Hi Alba – Thanks for taking my call earlier.

As discussed, the previous response I sent over stating 3m clearance was based on STW standard easement, the 3m clearance applies to all 225mm pipes.

LOCATION PLAN 1:500

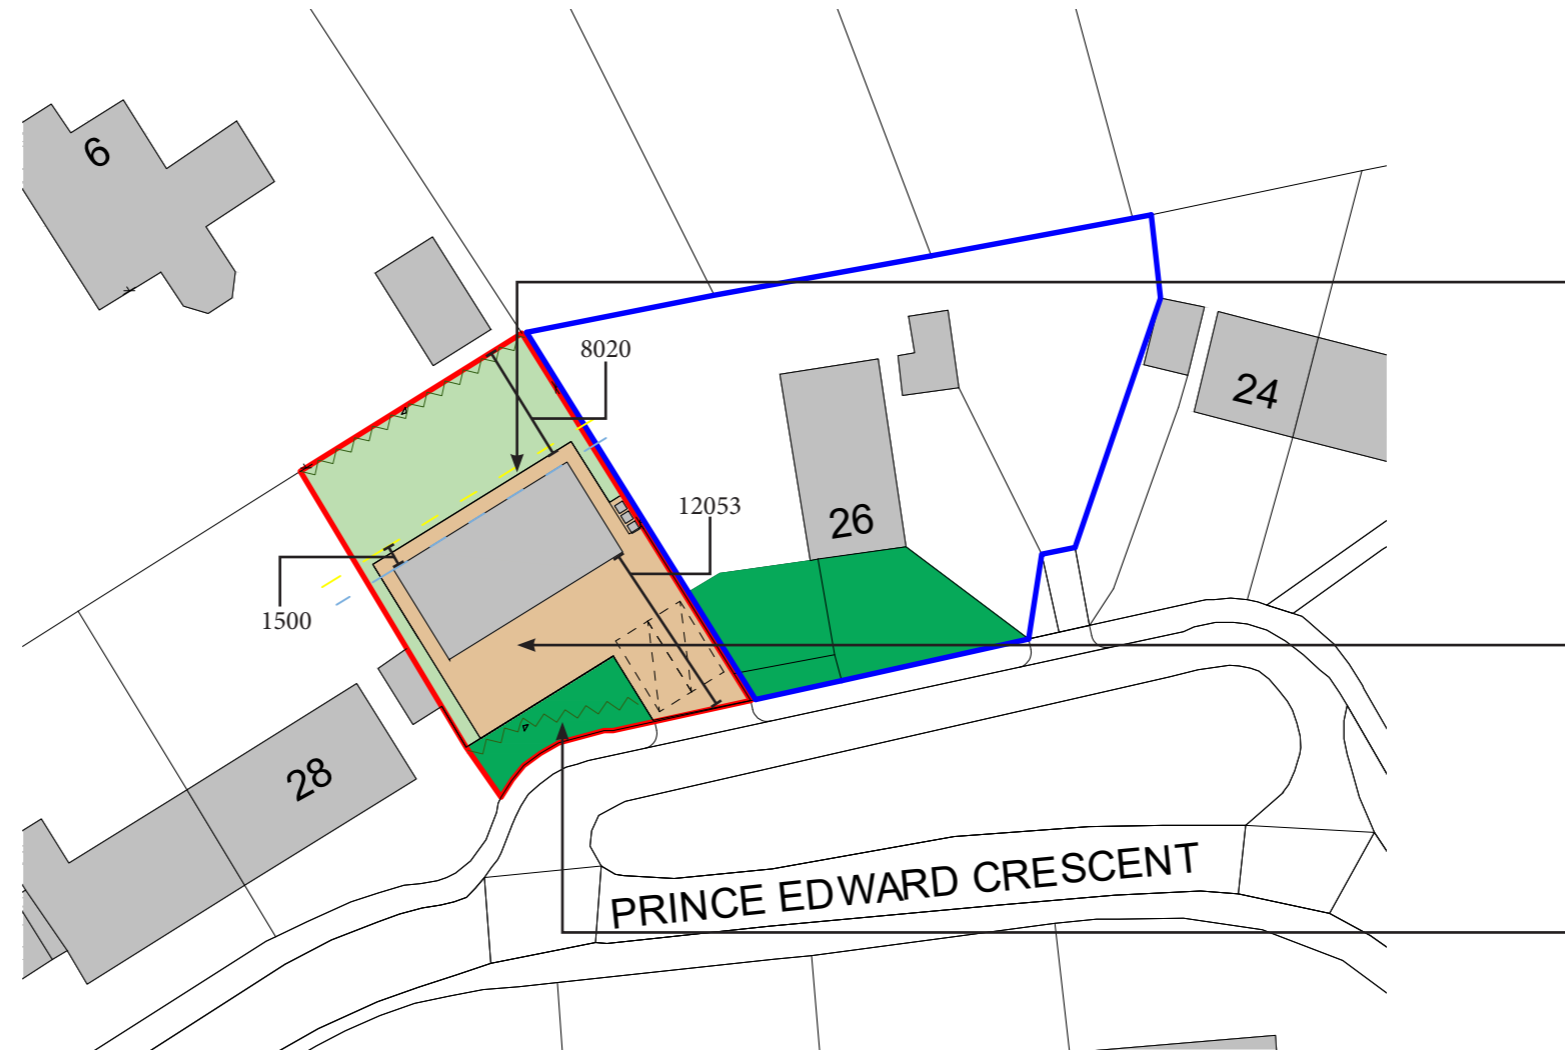
However, in this instance we will consider a build close to the diverted sewer providing we can achieve a minimum 600mm clearance:

- Please ensure the diversion has a minimum 600mm clearance from the edge of foundation to edge of pipe
- The MH chambers on either side of dwelling will require 500mm clearance from the edge to foundation.
- Long sectional drawing demonstrating there is no loading on the pipe, ensuring the foundations are taken below the pipe invert level to avoid potential loading.

Please provide a revised S185 demonstrating the above so we can consider your proposals further.
